Ref. FS-Case-570018056

18/12/2023

We, the residents of [REDACTED] object to the proposed planning amendment 3/2023/0903 on the following grounds:

Proposed Rear Elevation (2)

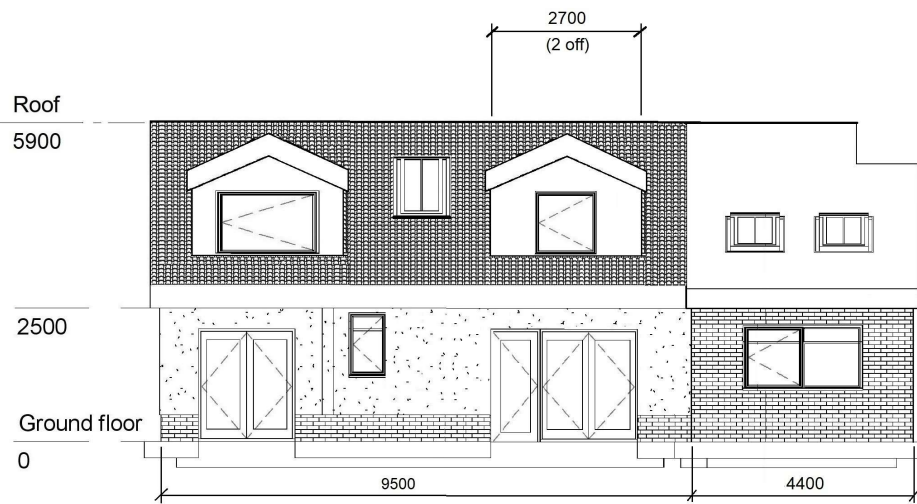
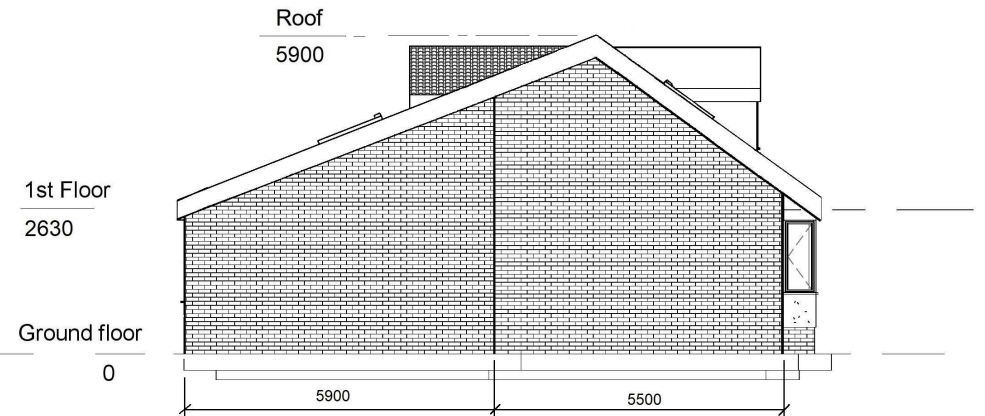
The latest application / amendment will take the property from **1 obscure window** [REDACTED] **to 5 new windows and rooflights**, hardly reflected in the planning report findings *the proposal would not be considered to create new opportunities for overlooking or loss of privacy*

We may withdraw this objection only if all glazing to the first floor rear elevation are fitted with obscure glass as was the case with the original property and remains the case for other altered bungalows on the same road.
